Engineers comments;

APPLICATION NO: WA/18/20/DOC

Site Address: Land East of Tye Lane Walberton

Description of Works: Approval of details reserved by condition imposed under ref
WA/95/18/RES relating to Condition No 4 - pedestrian, cyclist and
emergency access point

Client				
LINDEN HOMES SOUTH				
Project Title:				
LAND EAST OF TYE LANE, WALBERTON				
Drawing Title:				
PROPOSED OFF-SITE CULVERT WORKS				
A1 Scale		Date		Designed by
1:50		18.04.2019		JM
Drawn by		Checked by		Approved by
JM		JM		CH
Drawing Number		LHS240-1205		
		Rev T3

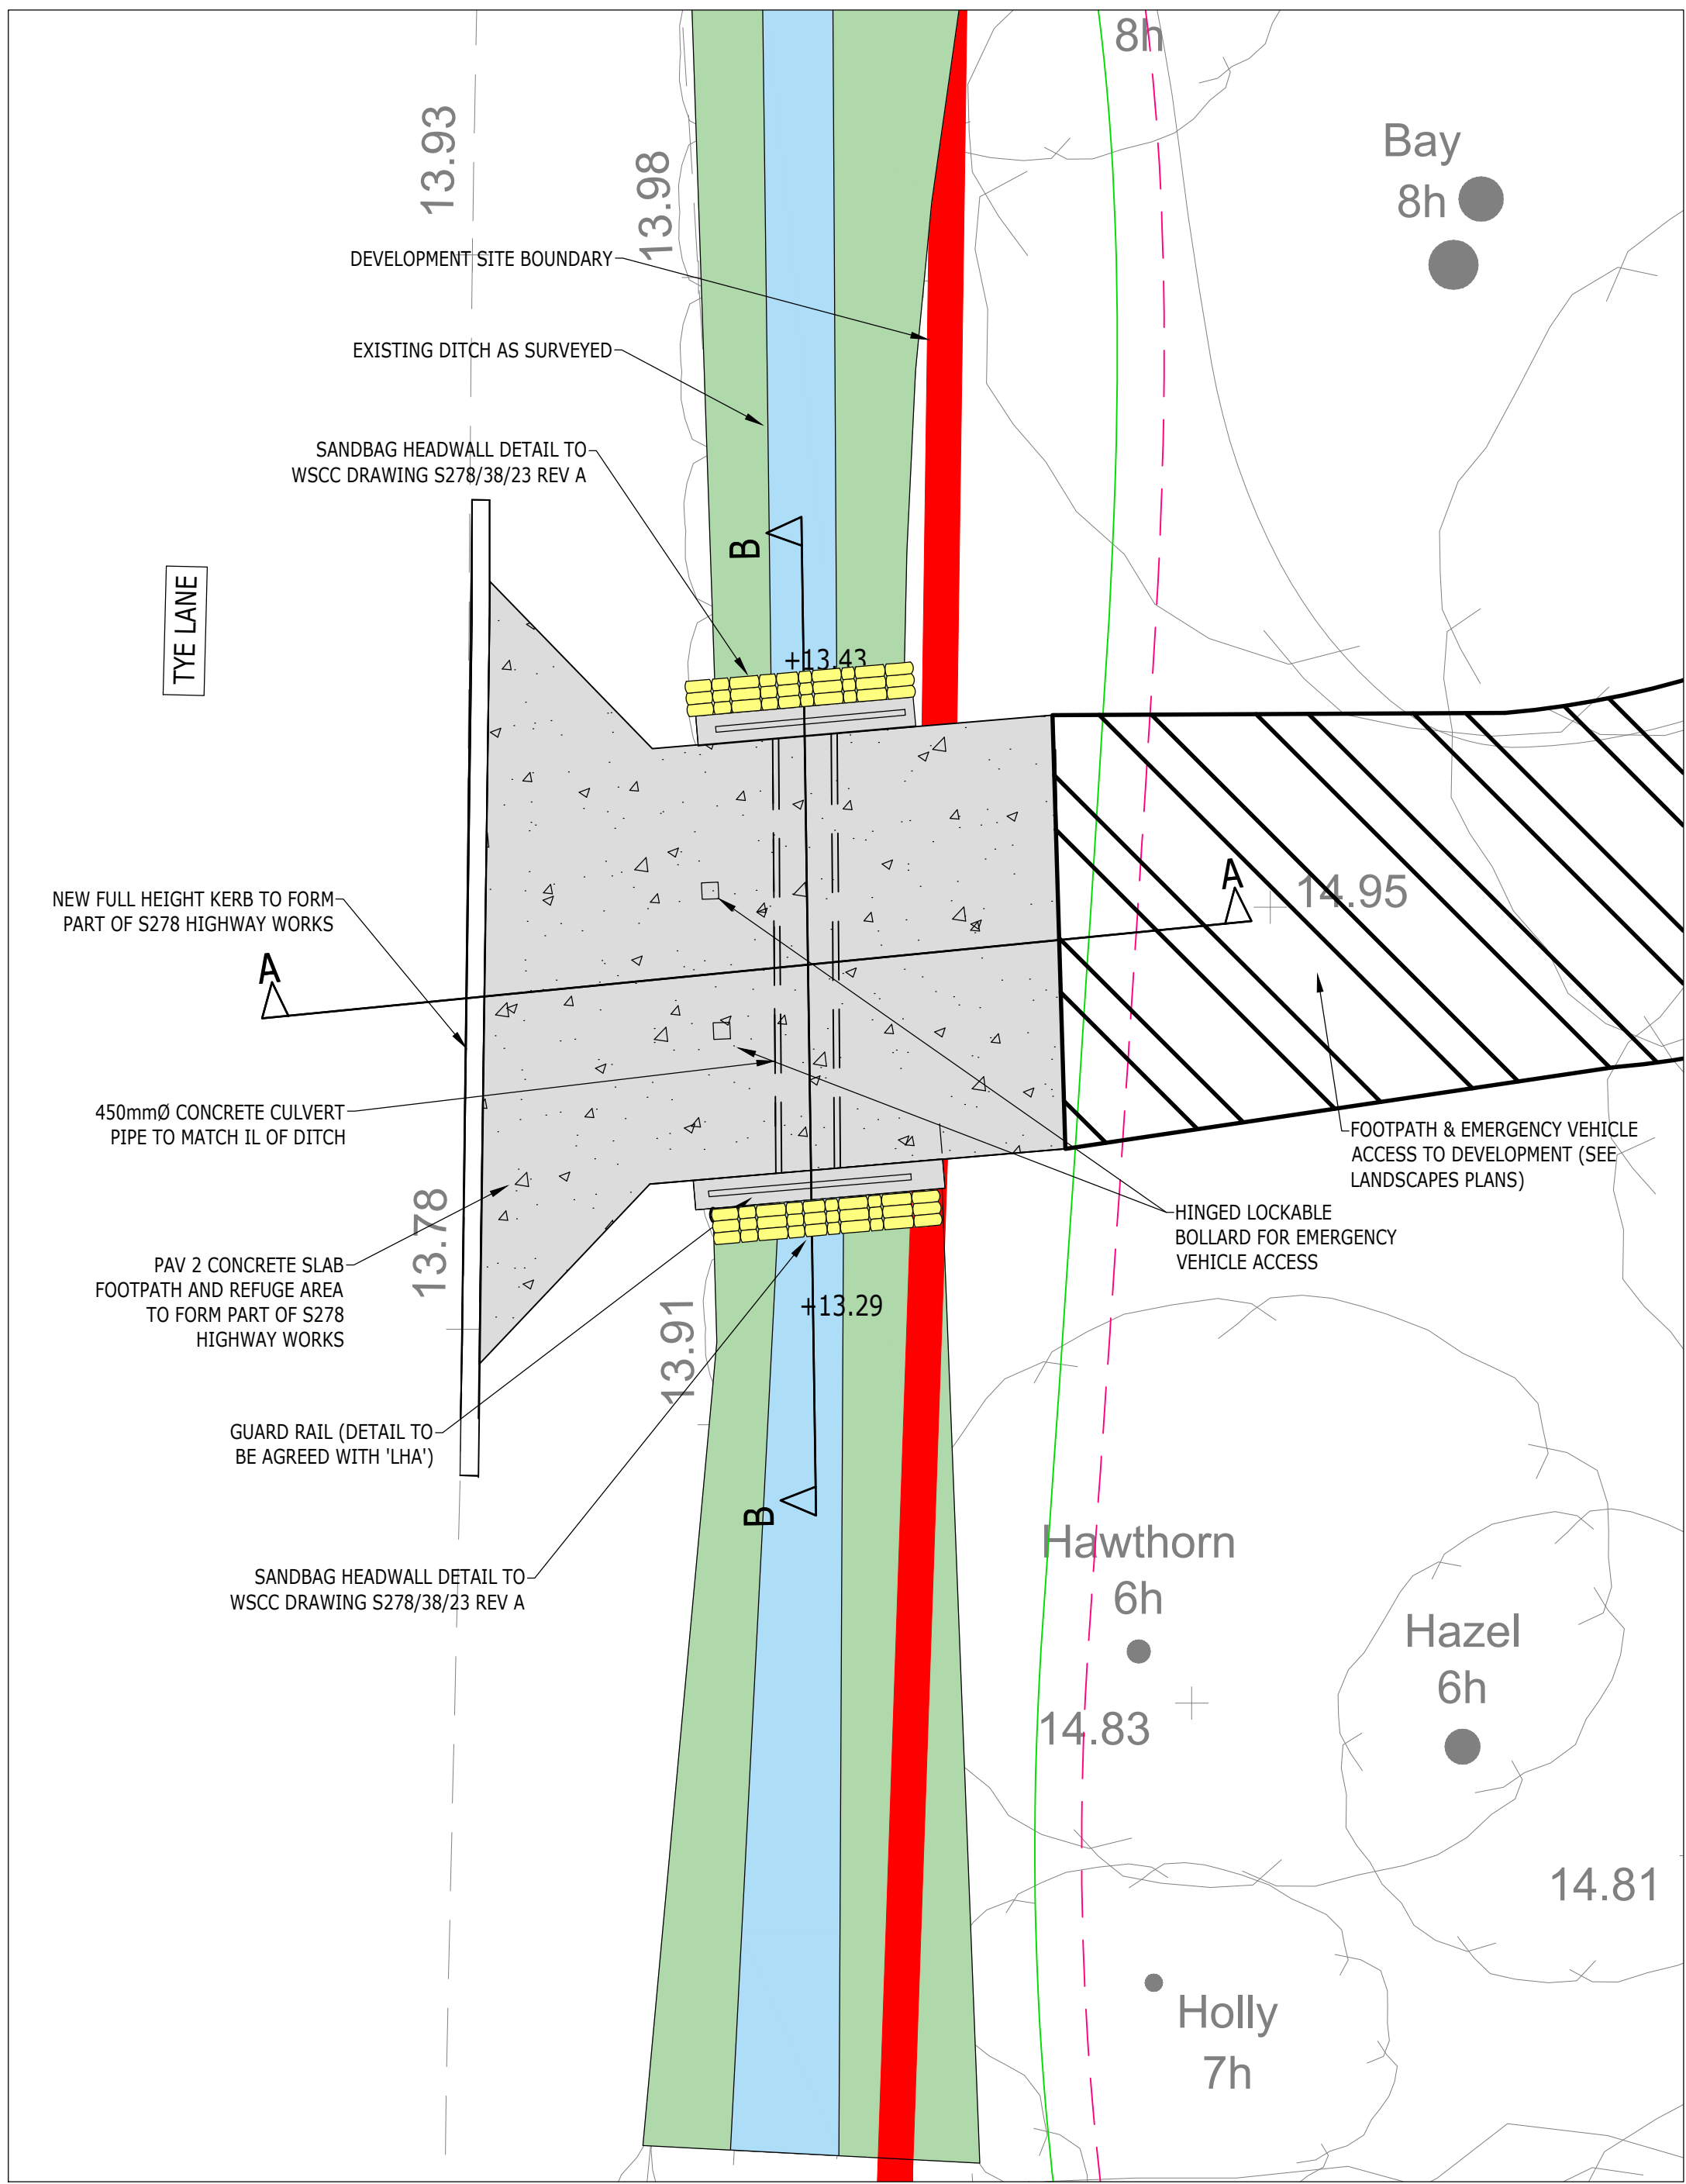
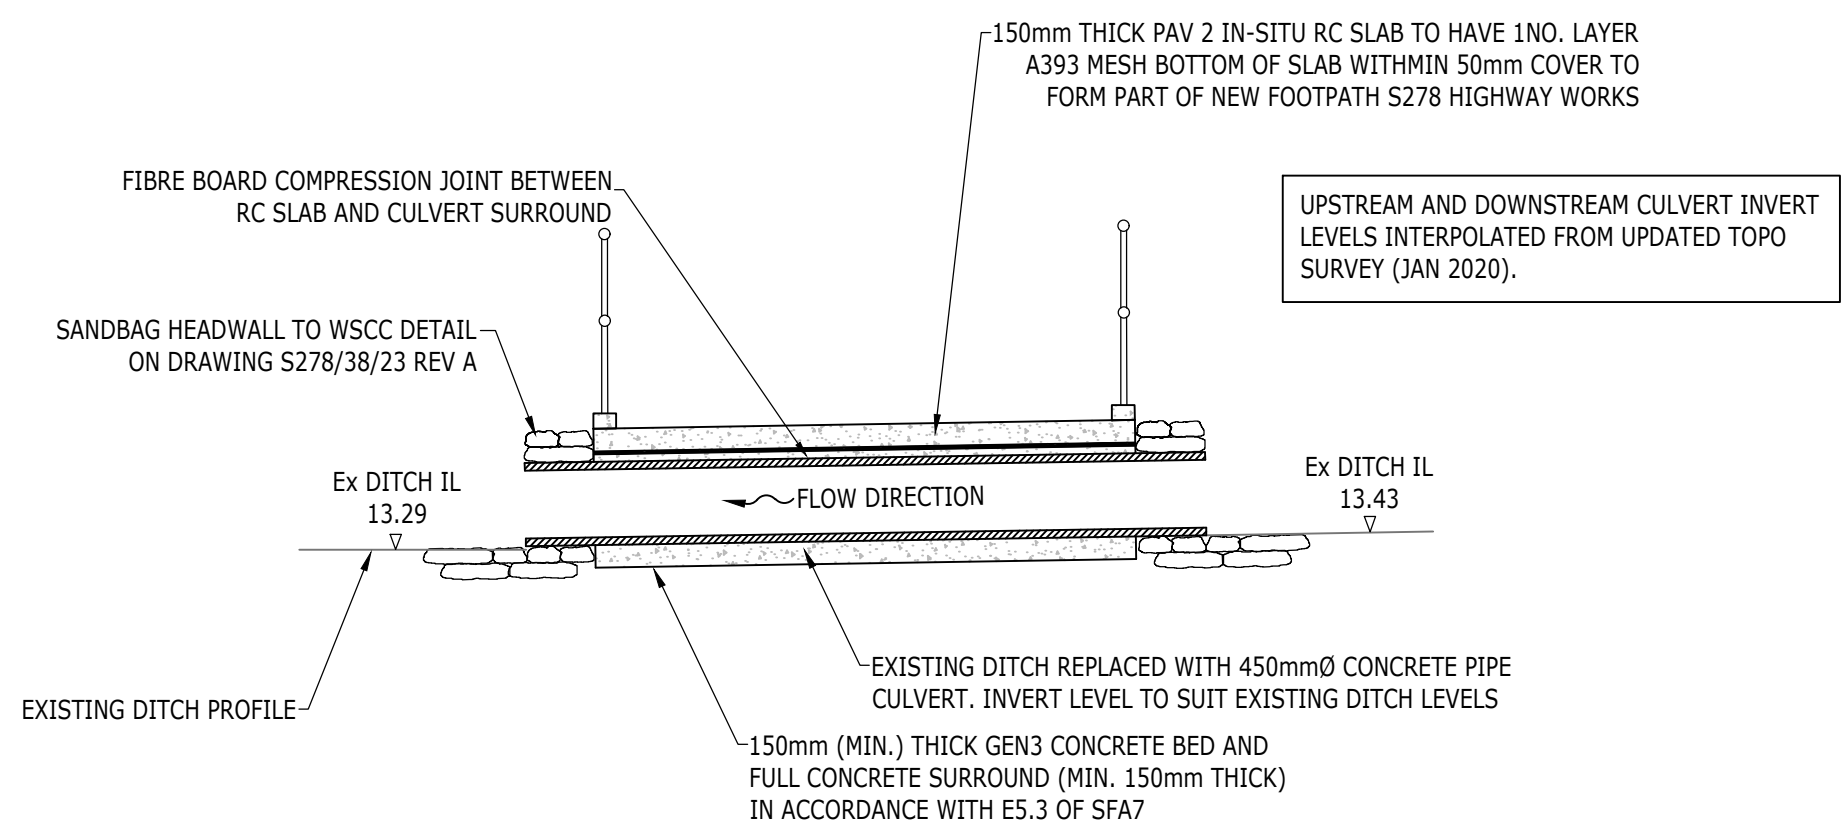
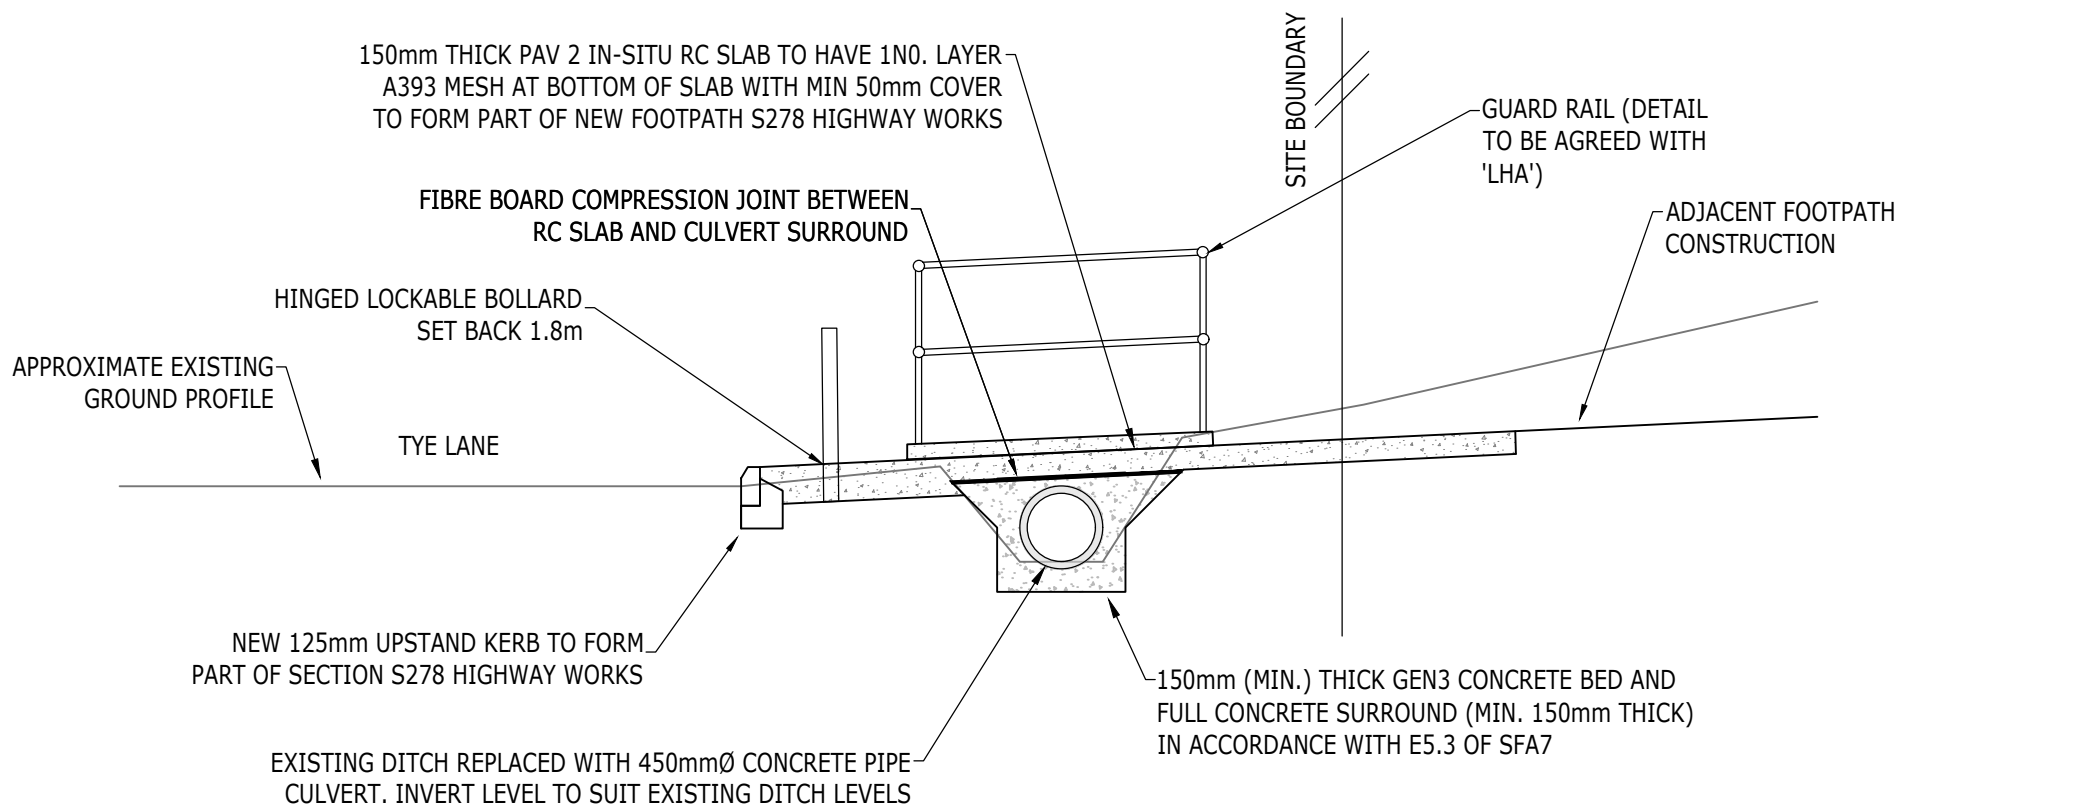
The proposals involve culverting (piping) a short section of ditch alongside Tye Lane. This proposal has been agreed and consented under the Land Drainage Act 1991. This is based upon the revised drawing enclosed and not the version on the planning portal.

I therefore have no objections to the proposals, based upon this revised drawing.
